EPC STORMWATER REVIEW COMMENTS
 IN ORANGE BOXES WITH BLACK TEXT

EL PASO COUNTY GRADING AND EROSION CONTROL PLAN CHECKLIST

EPC Project Number: **PPR255**

Landscape Endeavors Building Addition
 CES Endeavors, LLC
 Grading and Erosion Control - Details
 El Paso County, Colorado

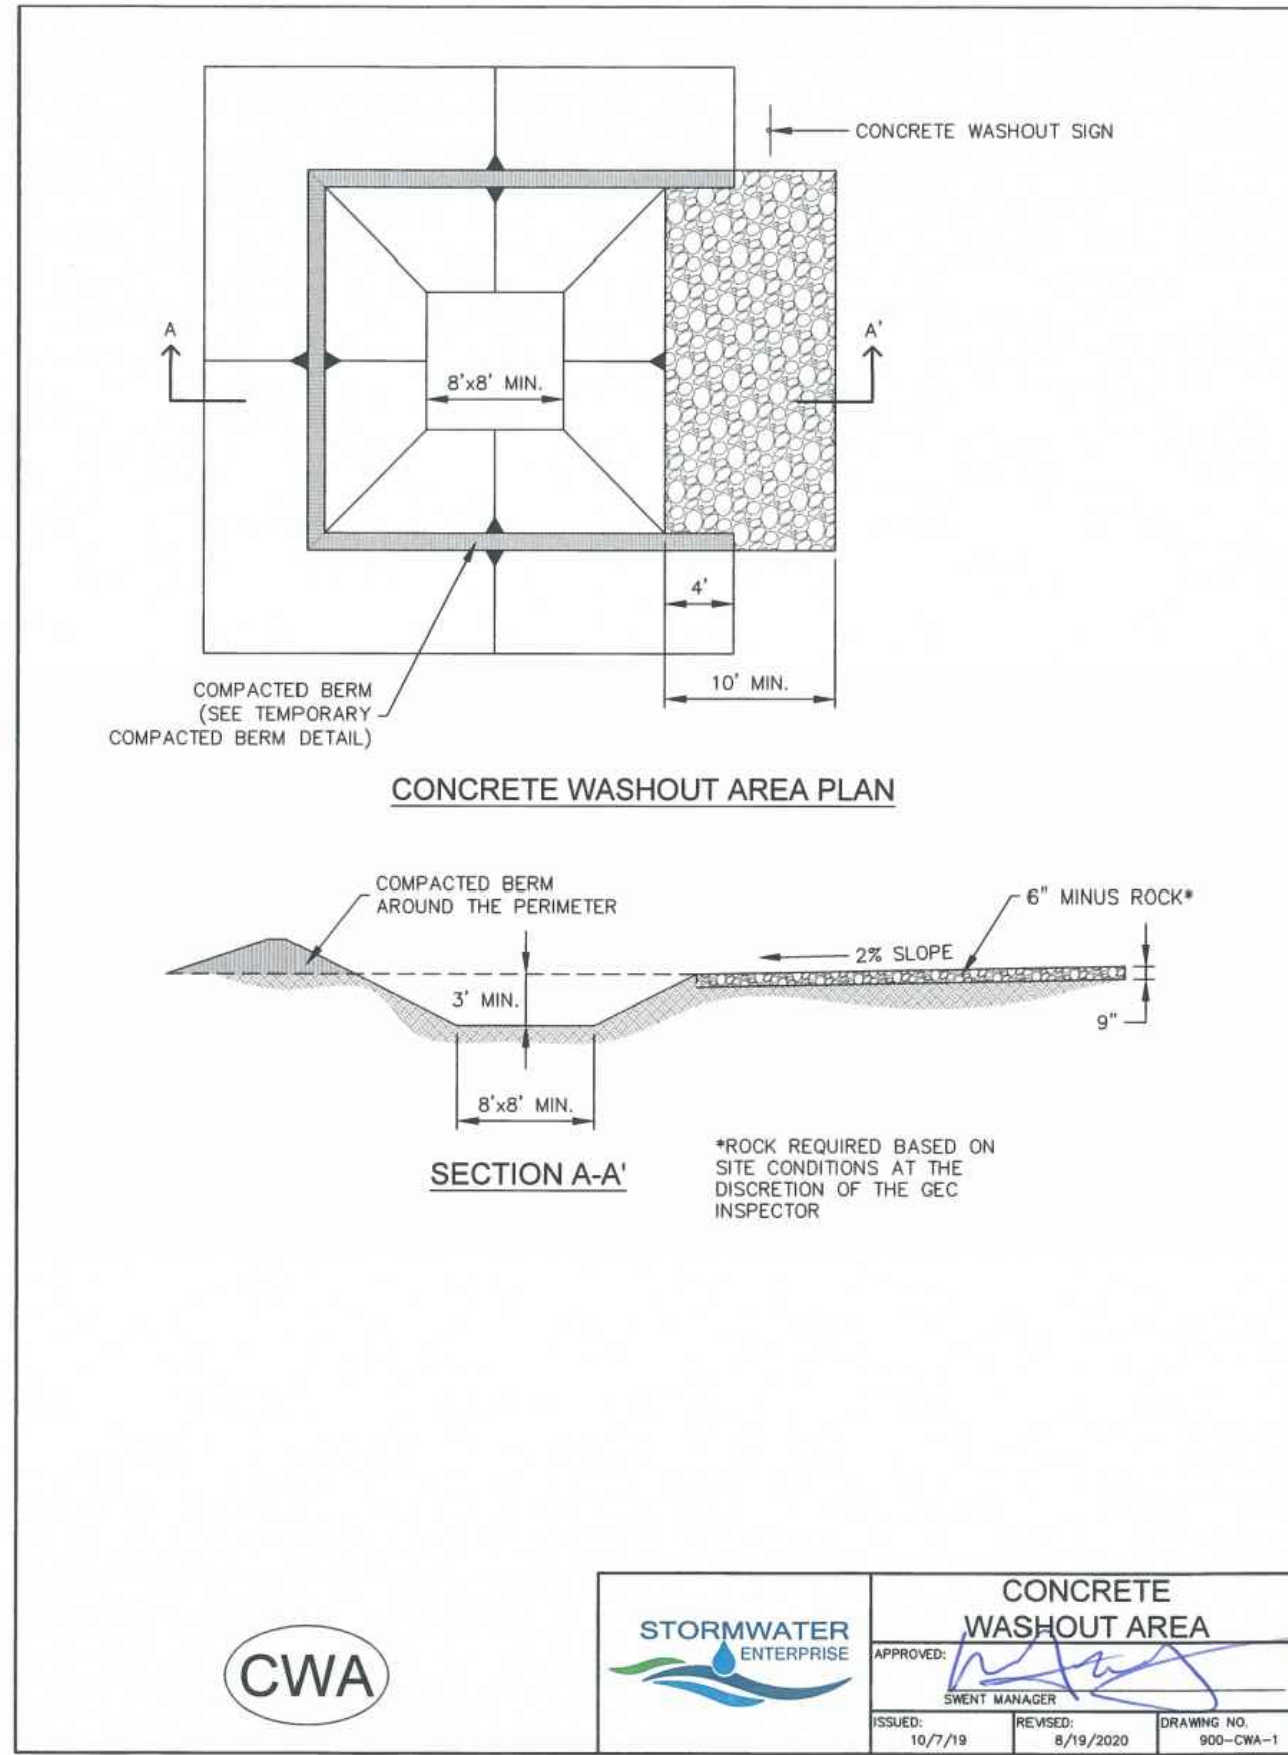
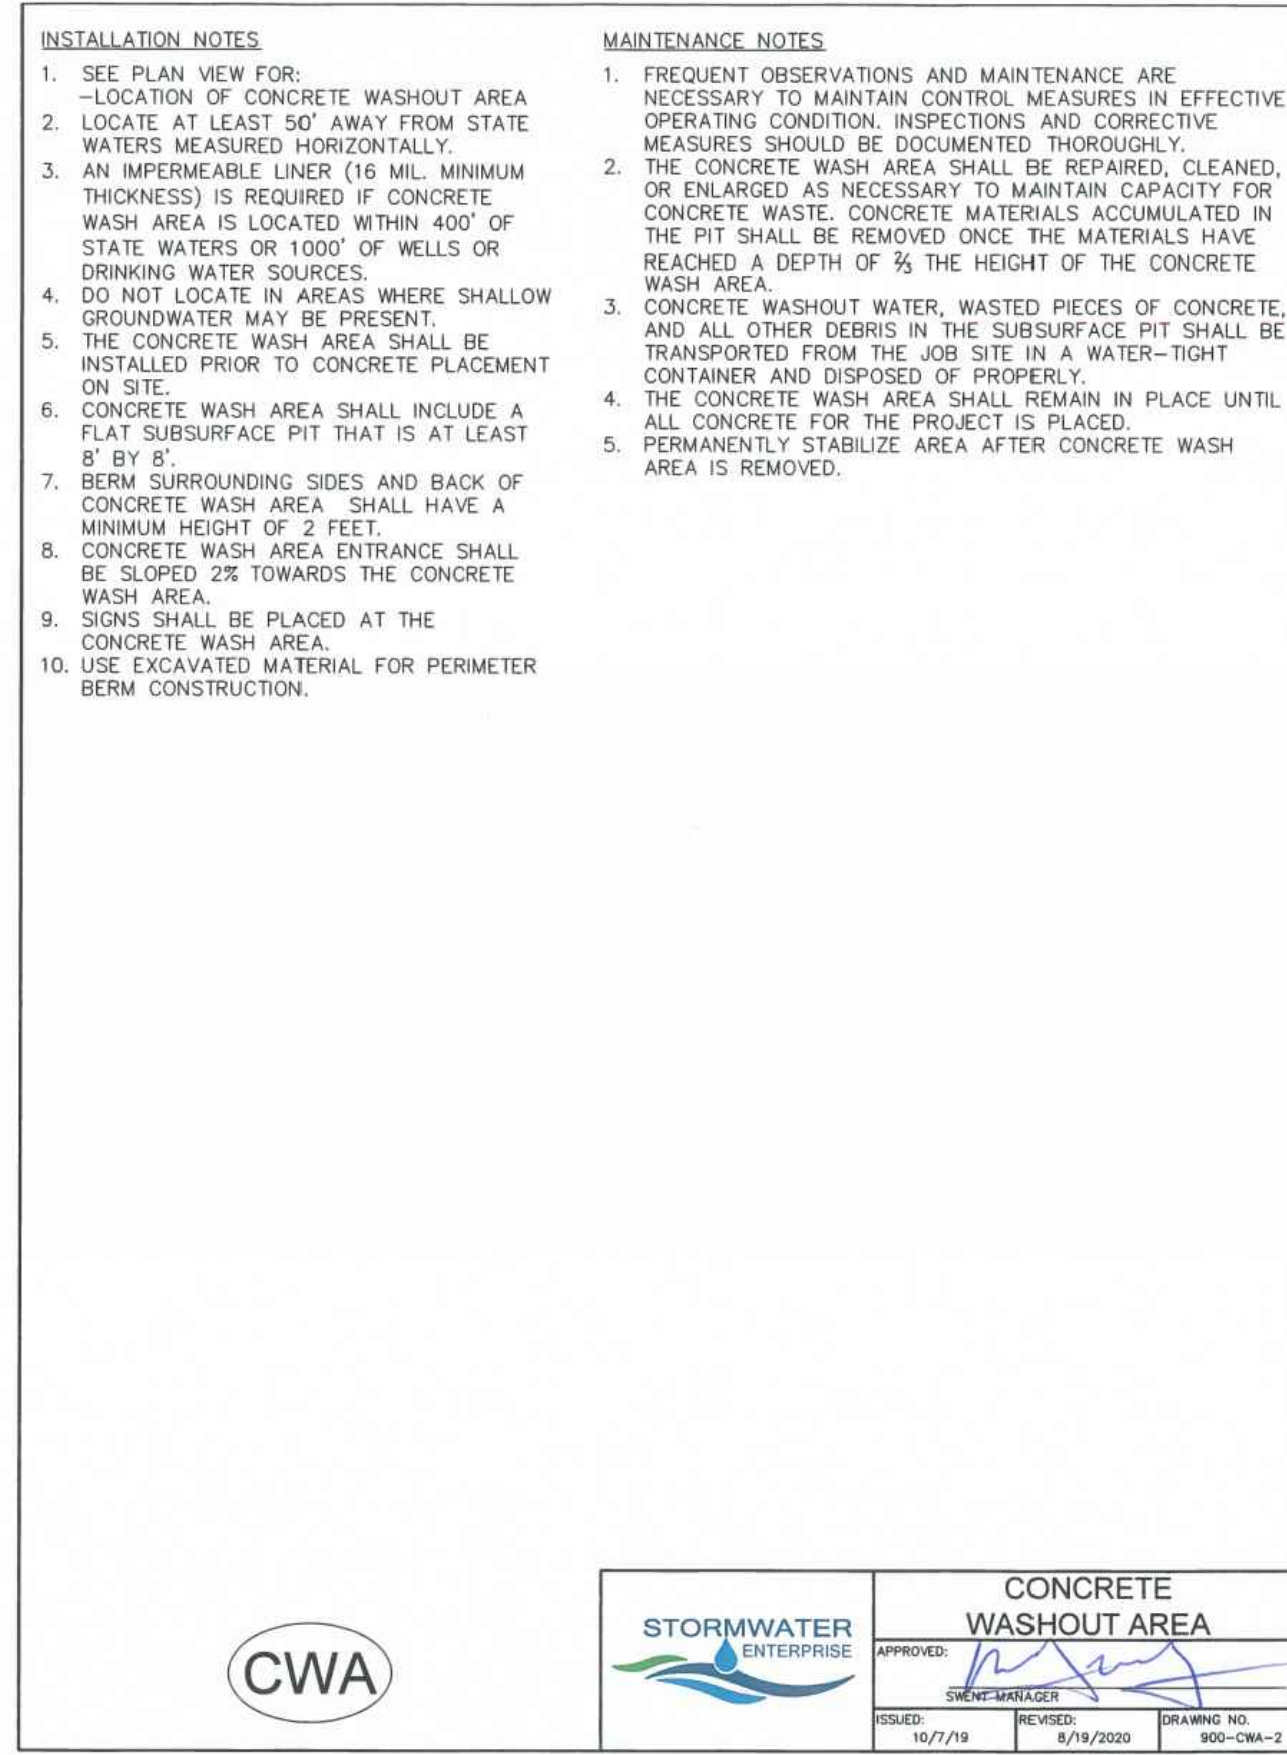
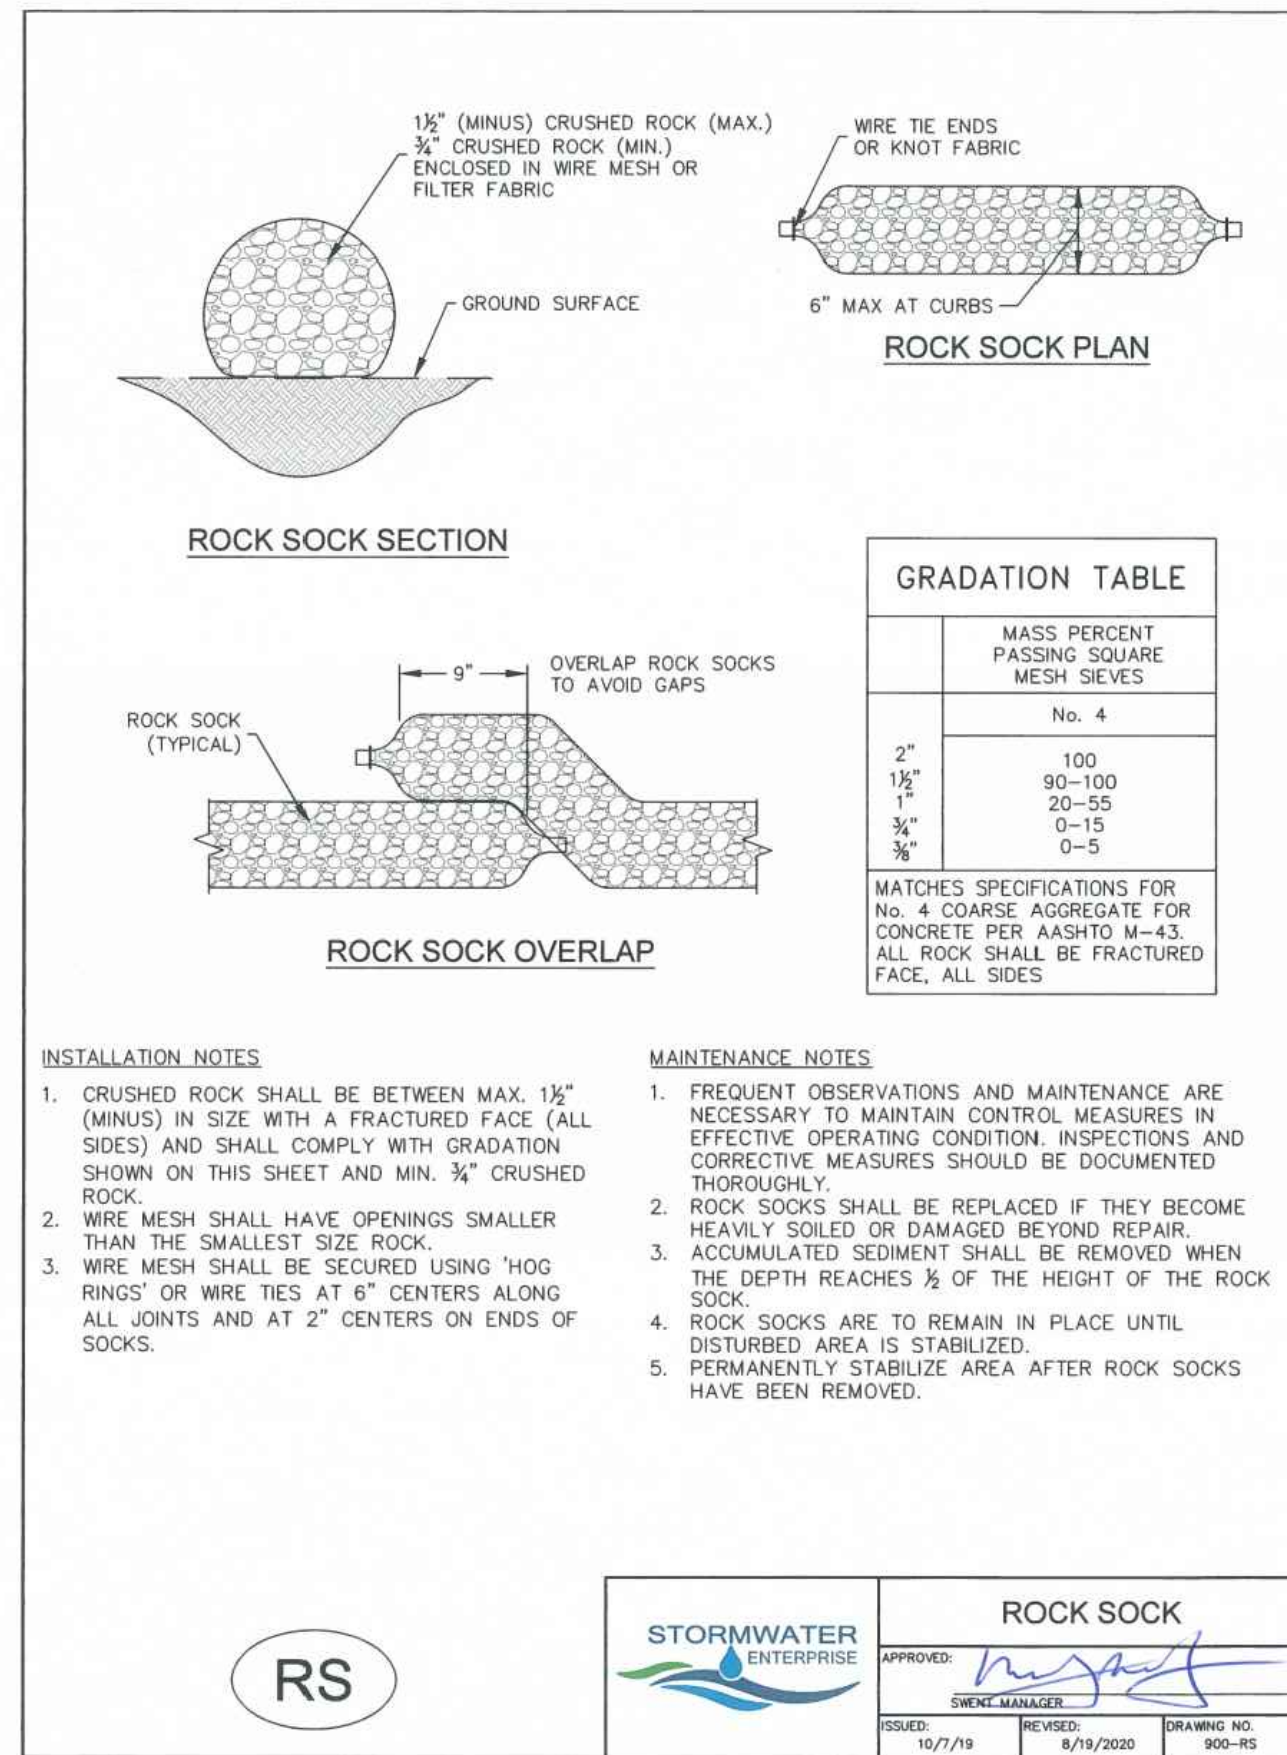
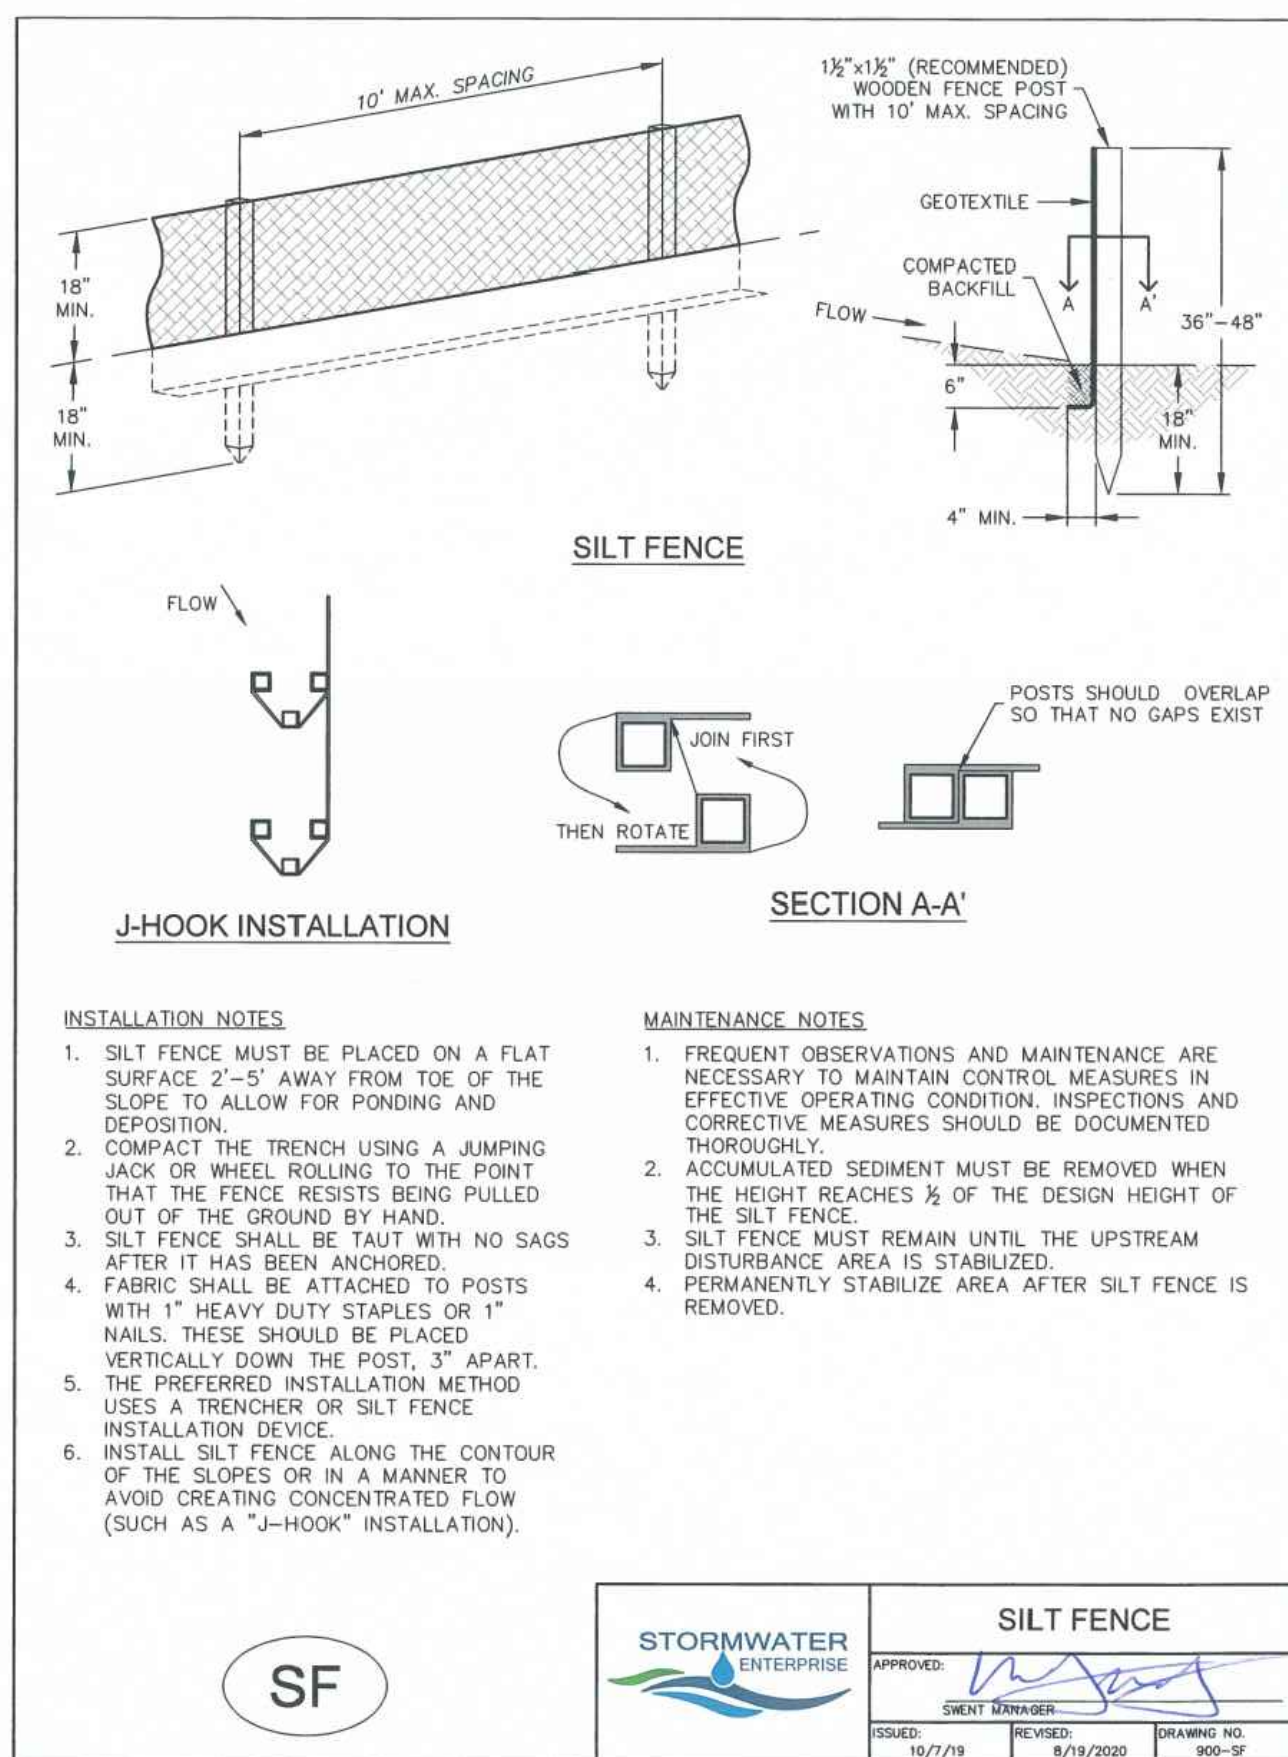
Applicant	EPC
y	Dewatering operations to include locations of diversion, pump and discharge(s) as anticipated at time of design		N/A
z	All proposed temporary construction control measure details. Custom or other jurisdiction's details used must meet or exceed EPC standards		N
aa	Any off-site stormwater control measure proposed for use by the project and not under the direct control or ownership of the Owner or Operator		N
bb	Existing and proposed permanent storm water management facilities, including areas proposed for stormwater infiltration or subsurface detention		N
cc	Existing and proposed easements (permanent and construction) including required off-site easements		Y
dd	Retaining walls shall not to be located in County ROW unless approved via license agreement. A building permit from Regional Building Department is required for walls greater than or equal to 4 feet in height, series of walls, or walls supporting a surcharge and must be design by P.E.
